**ADDENDUM 2 TO THE  
FINAL DRAINAGE REPORT  
FOR  
HOMESTEAD AT STERLING RANCH FILING NO. 2**

**EPCD File No. SF-19-004/CDR-20-012**

**December 27, 2022  
Project No. 25188.29**

**NORTH SAND FILTER
LONGITUDINAL CROSS
SECTION DETAILS**
NOT TO SCALE

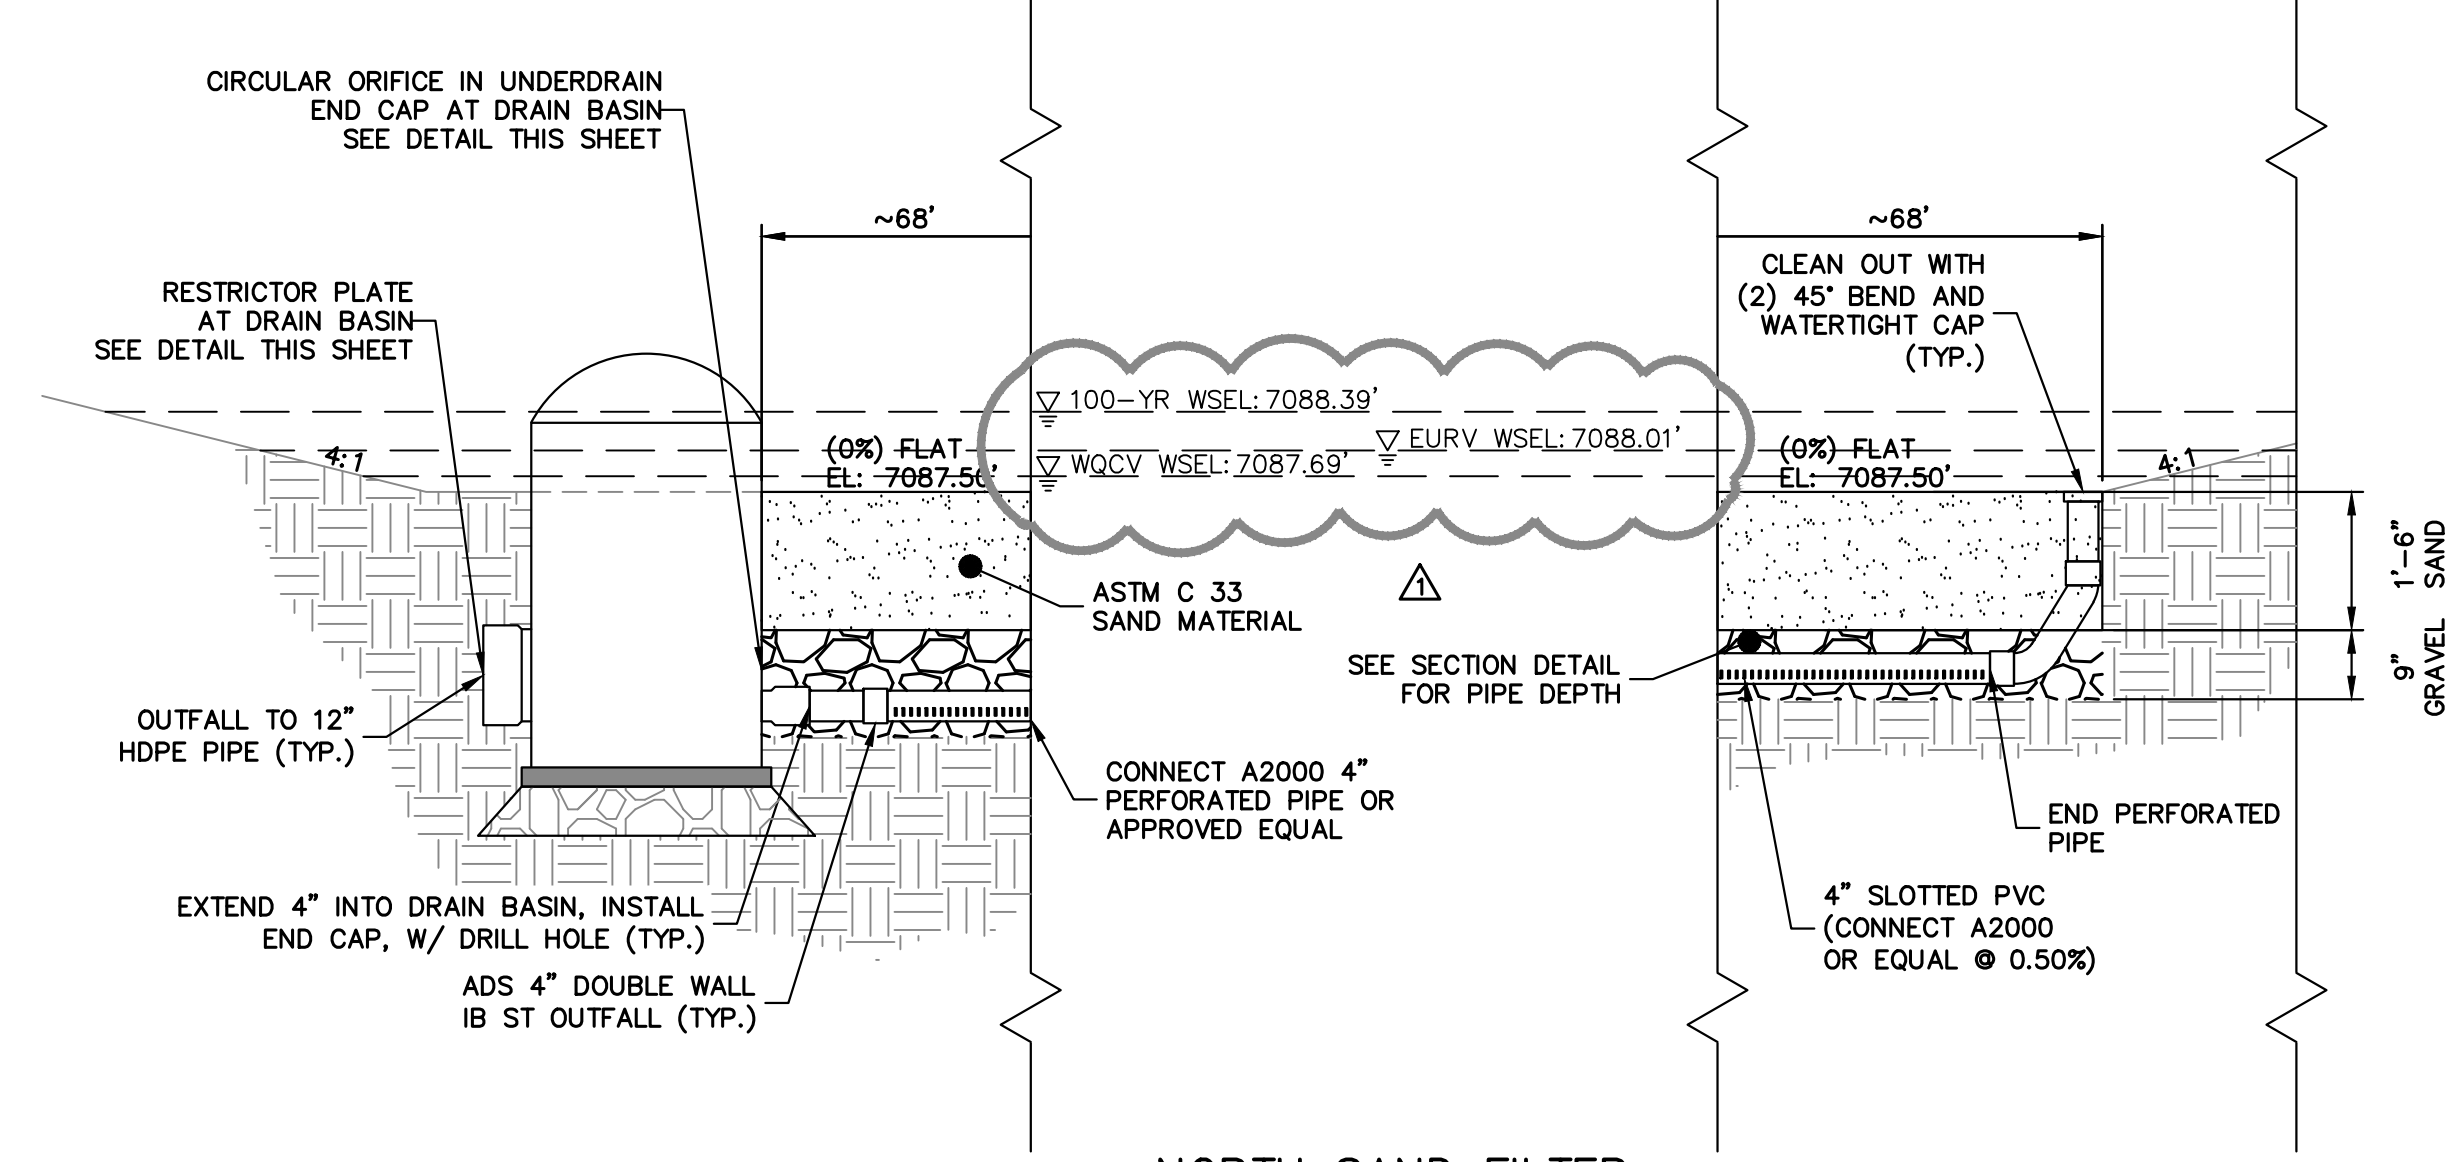
Put "North Sand Filter" in parenthesis here since that's also what it is called on Sht 8 of GEC Plans

**SOUTH SAND FILTER
LONGITUDINAL CROSS
SECTION DETAILS**
NOT TO SCALE

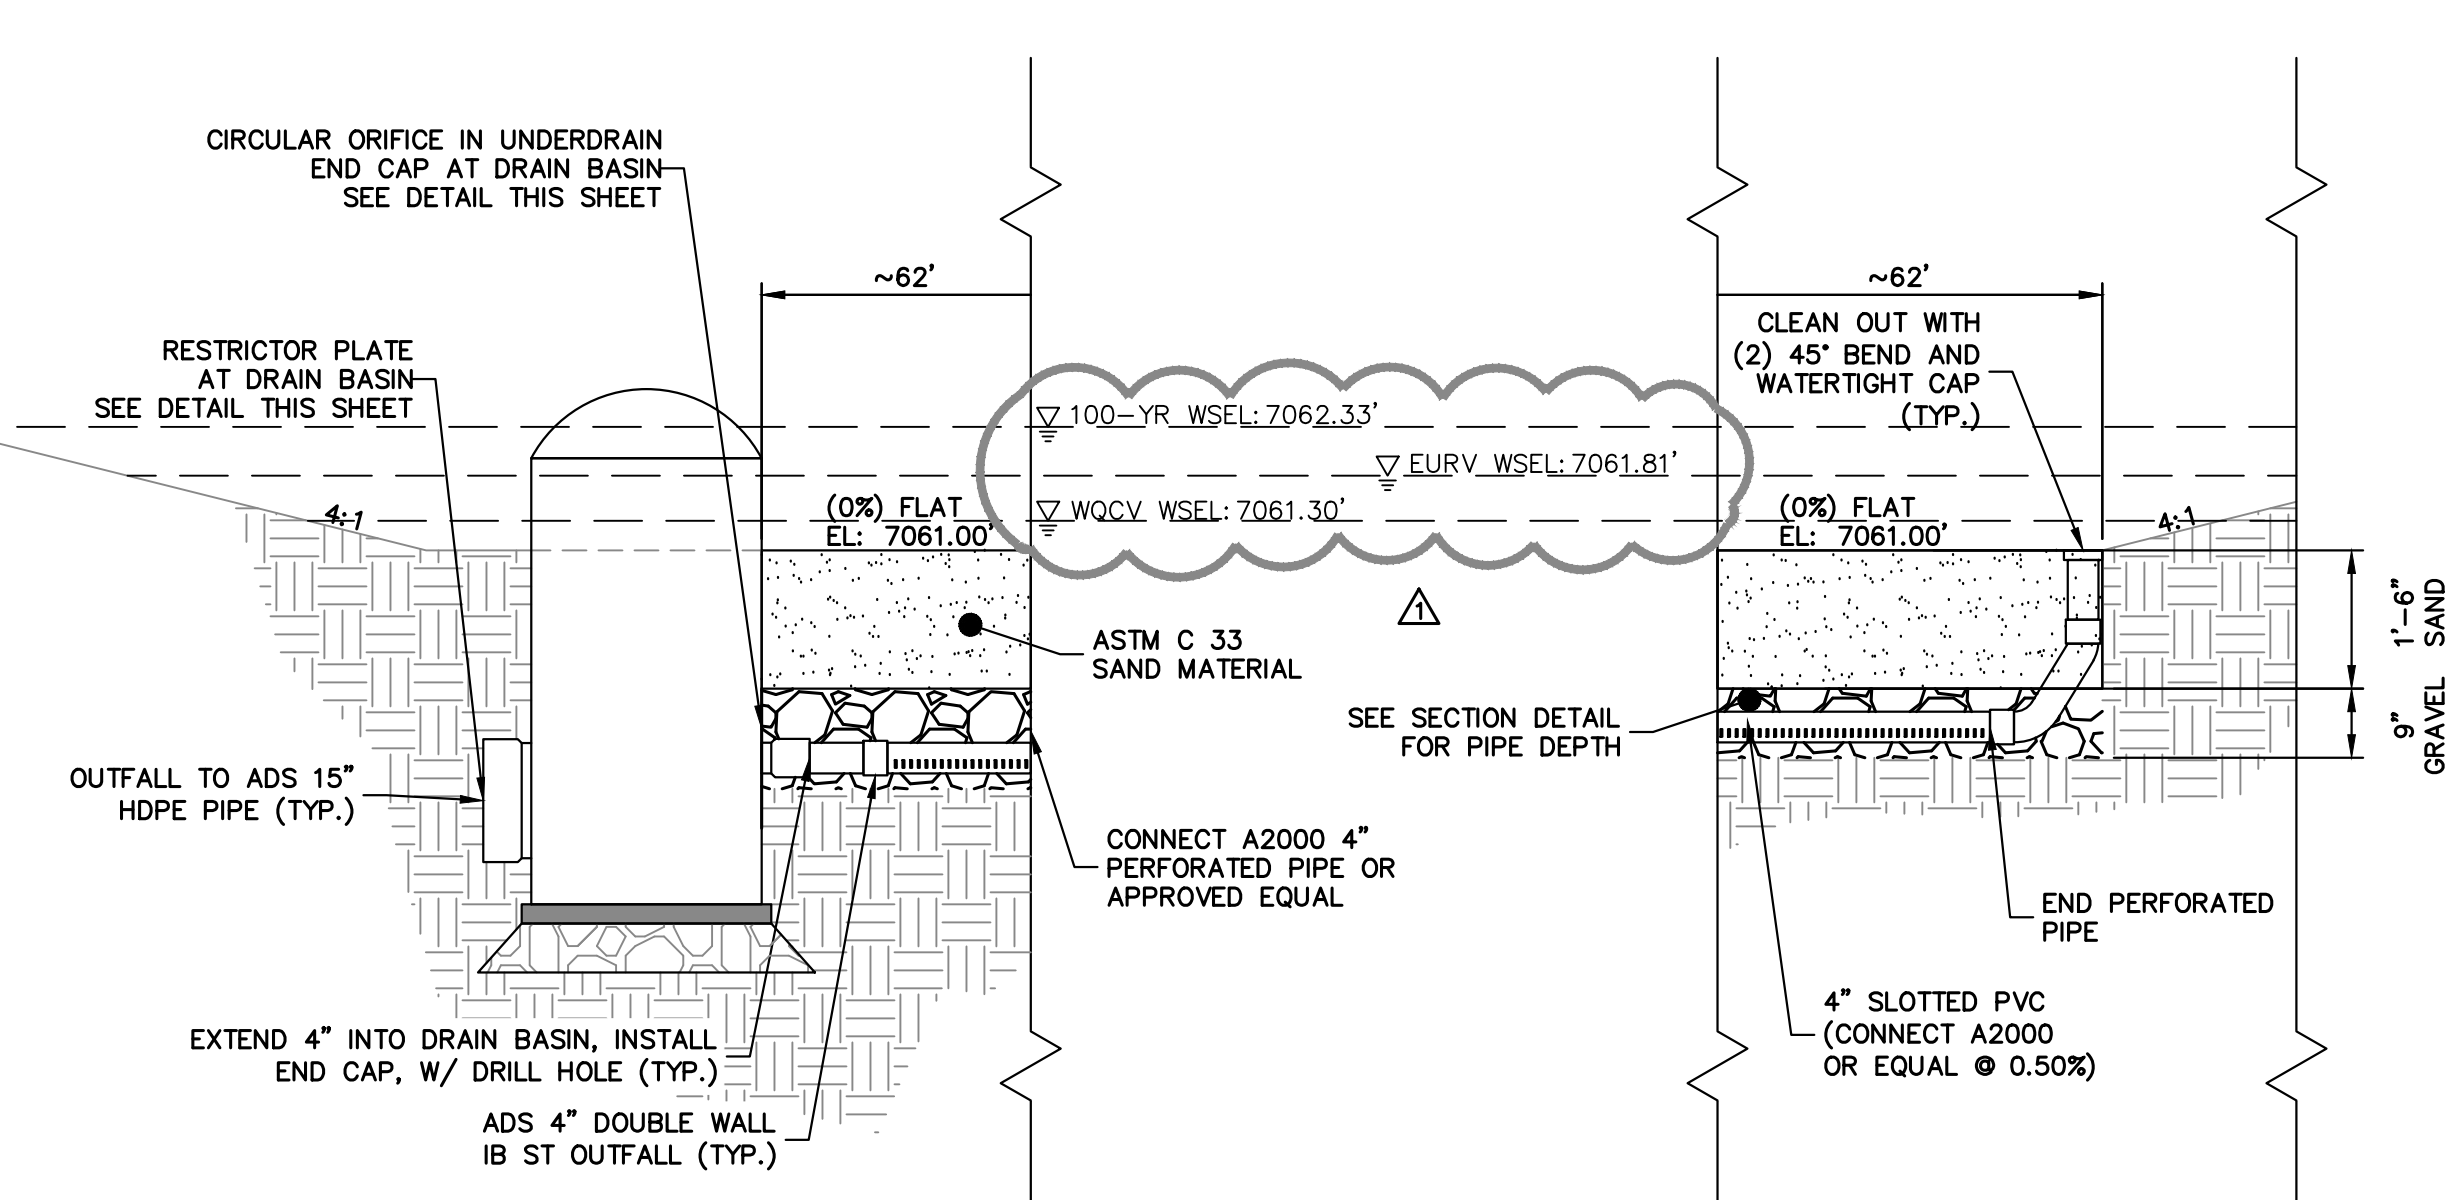
add: "(South Sand Filter)"

**NORTH SAND FILTER
EMERGENCY SPILLWAY**
SCALE: 1"=2'

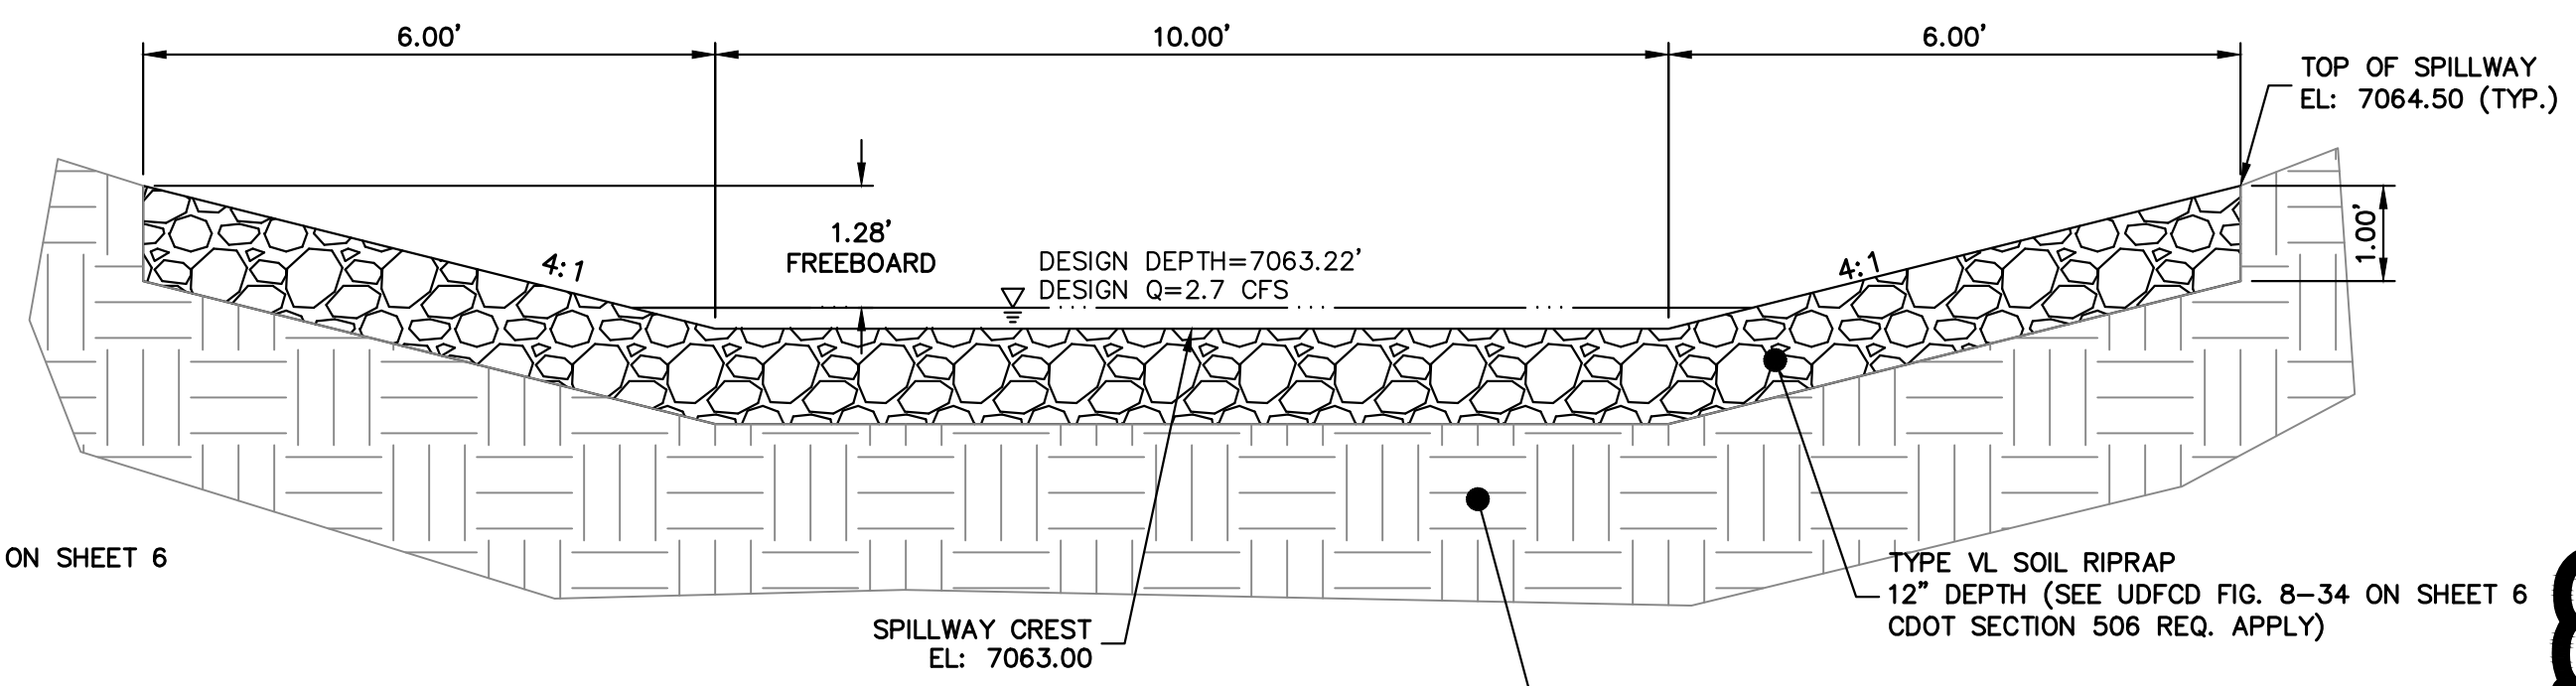
shown as 2.5ft on Sht 8 of GEC Plans and in calcs on pdf pg 15 below. Revise to remove discrepancy.
